Modification of Minister's Approval

MP08_0054 granted by the then Minister for Planning on 16 December 2008

Project approval for a new health facility development at the Royal Rehabilitation Centre Sydney, 600-640 Victoria Road, Ryde (Lot 1010 in DP 836975) including:

MP08_0054 MOD 7: the modification includes:

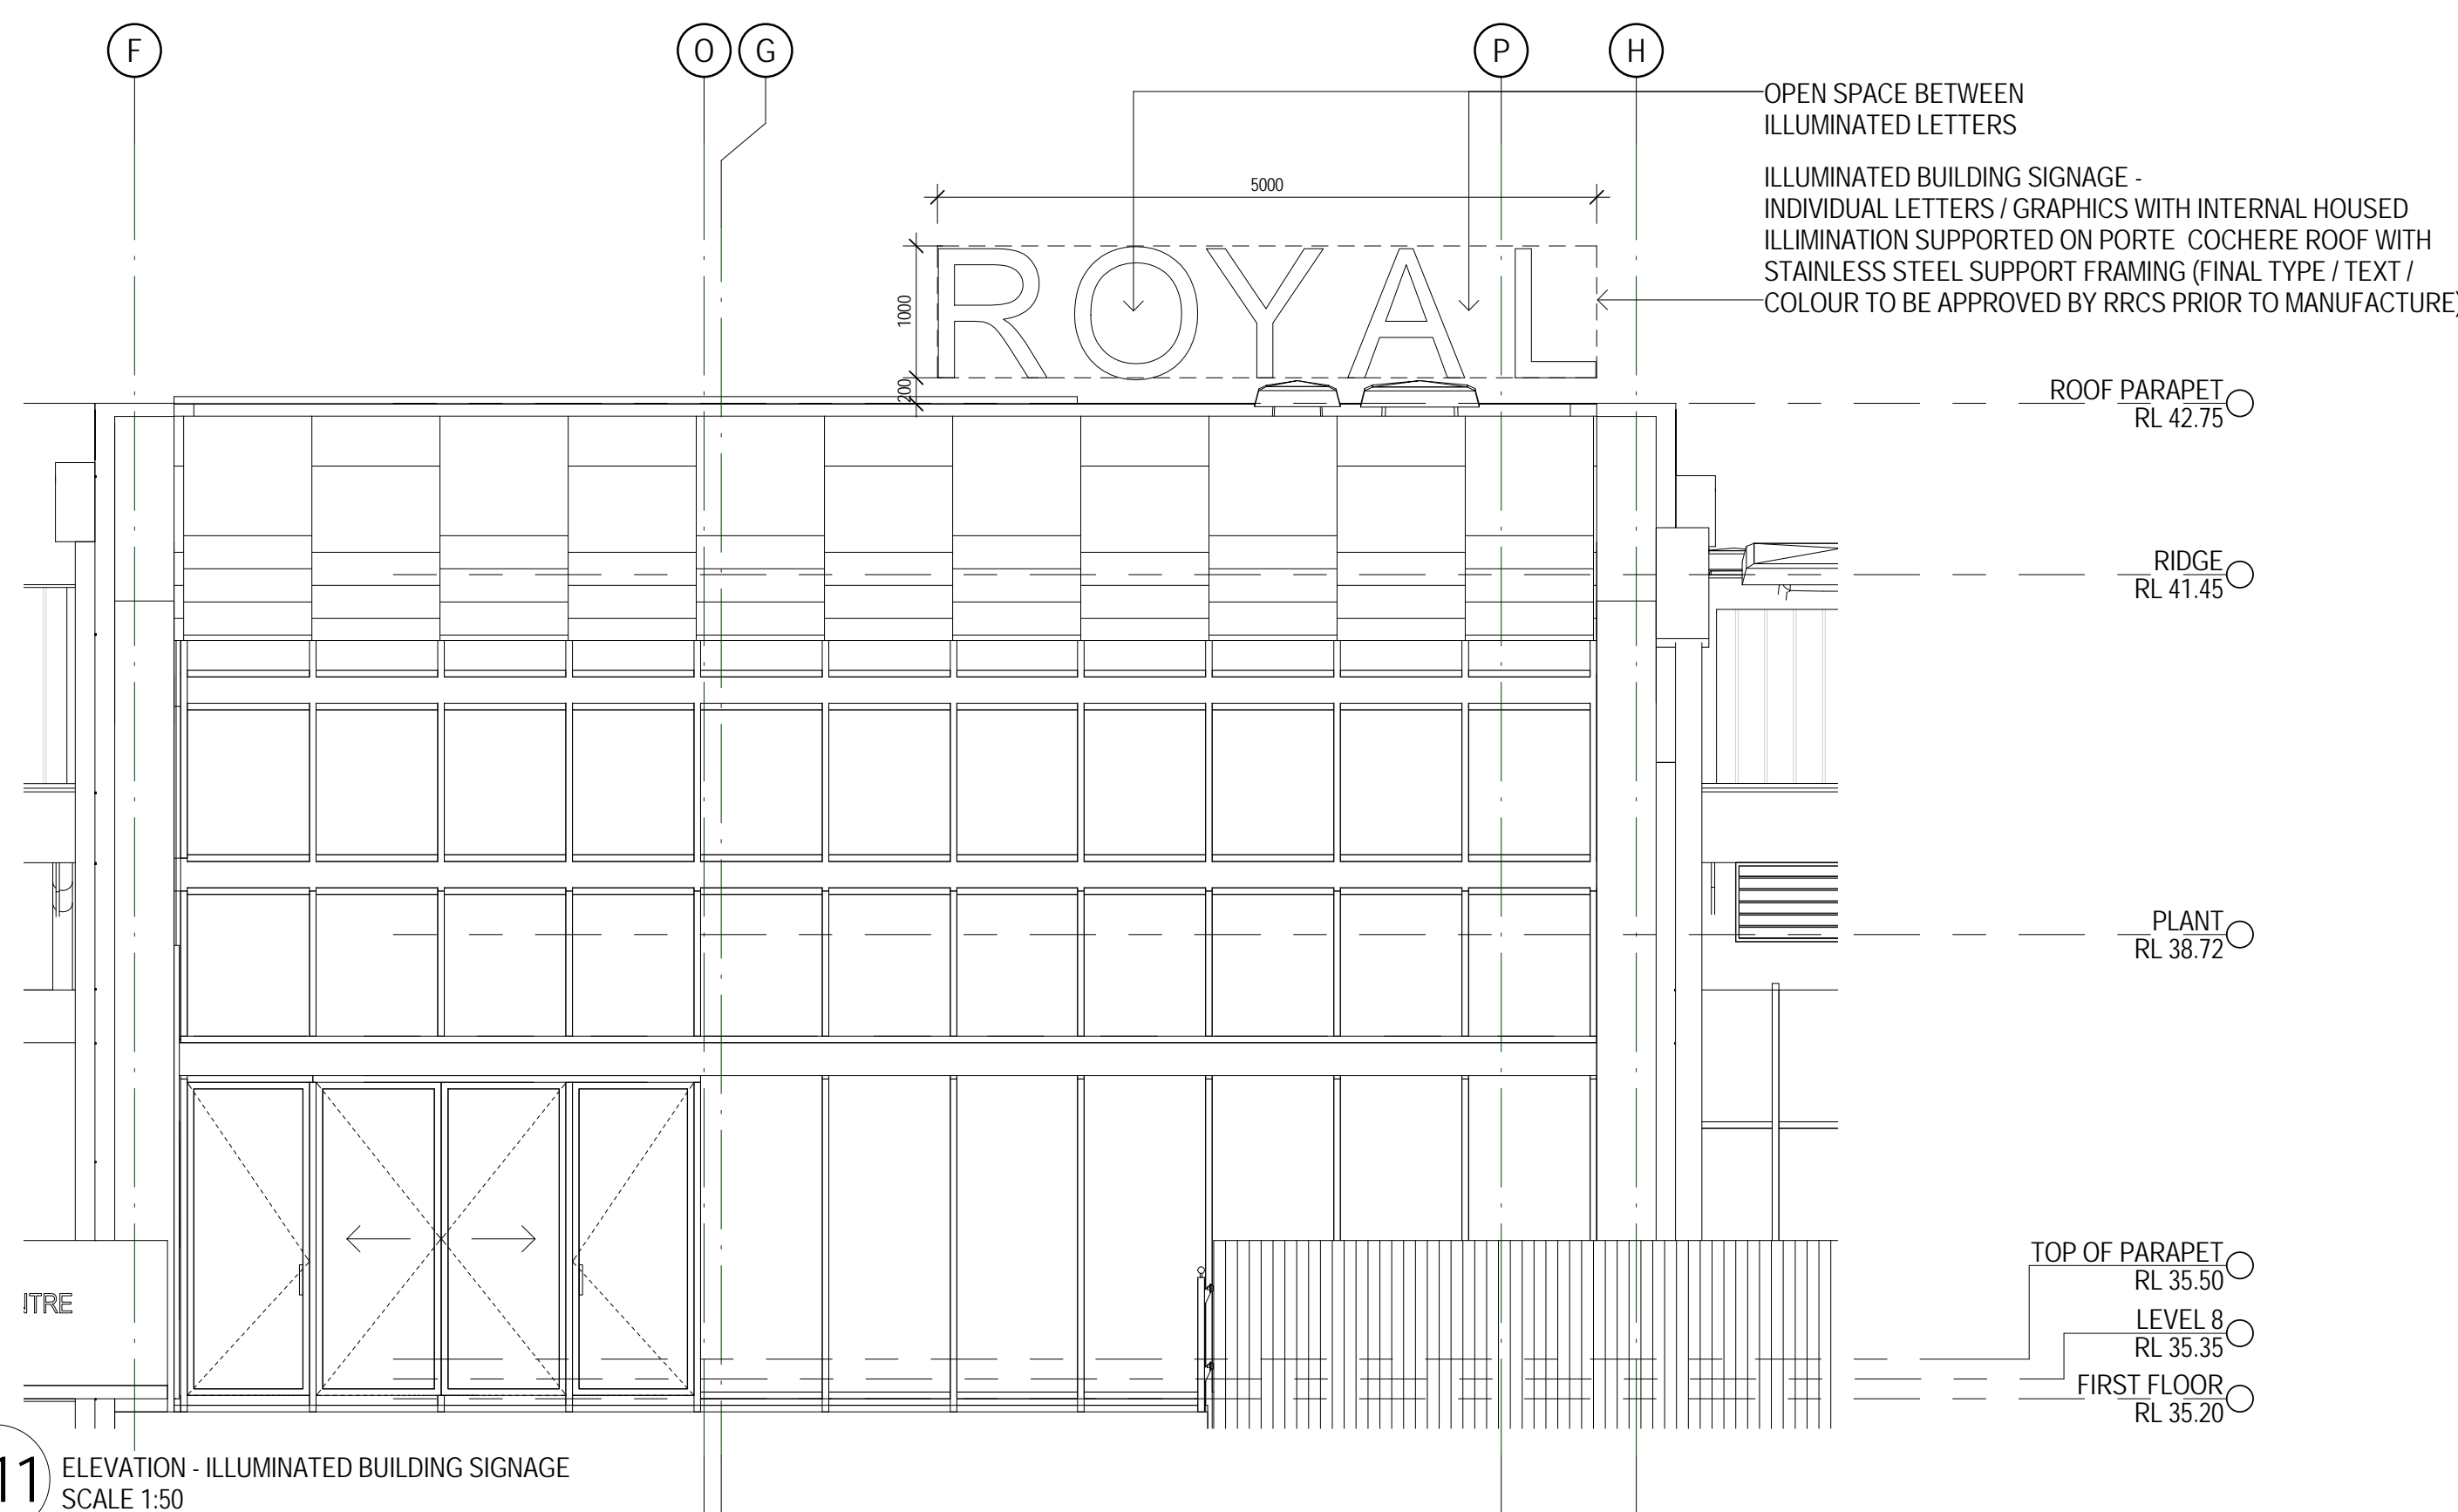
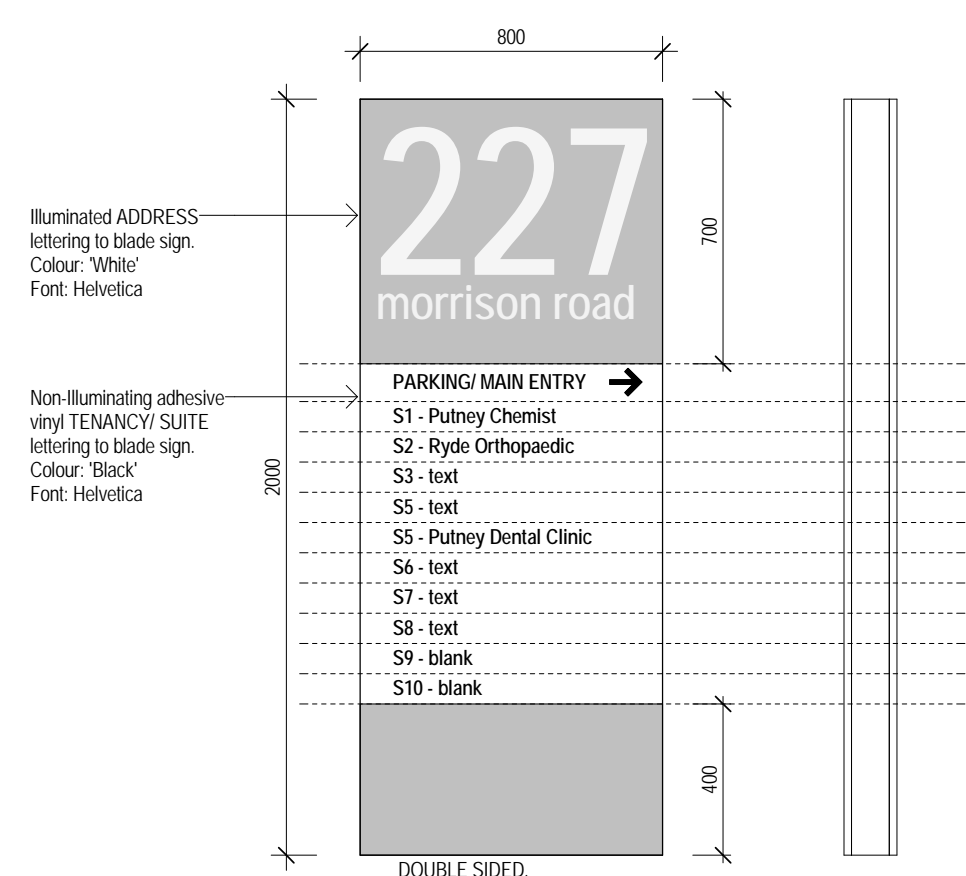
- (b) Schedule 2 Part A – Administrative Conditions, Condition A17 is amended by the insertion of the **not cause distraction to the traffic on Morrison Road;** words / numbers and deletion of the **~~bold struck out~~** words/numbers as follows:

- a) **not cause distraction to the traffic on Morrison Road;**
- b) **not cause glare or adversely impact to the adjoining buildings/residential properties;**
- c) **comply with AS4282-1997: Control of Obtrusive Effects of Outdoor Lighting; and**
- d) **not be of flashing type, animated display, moving parts or simulated movement.**
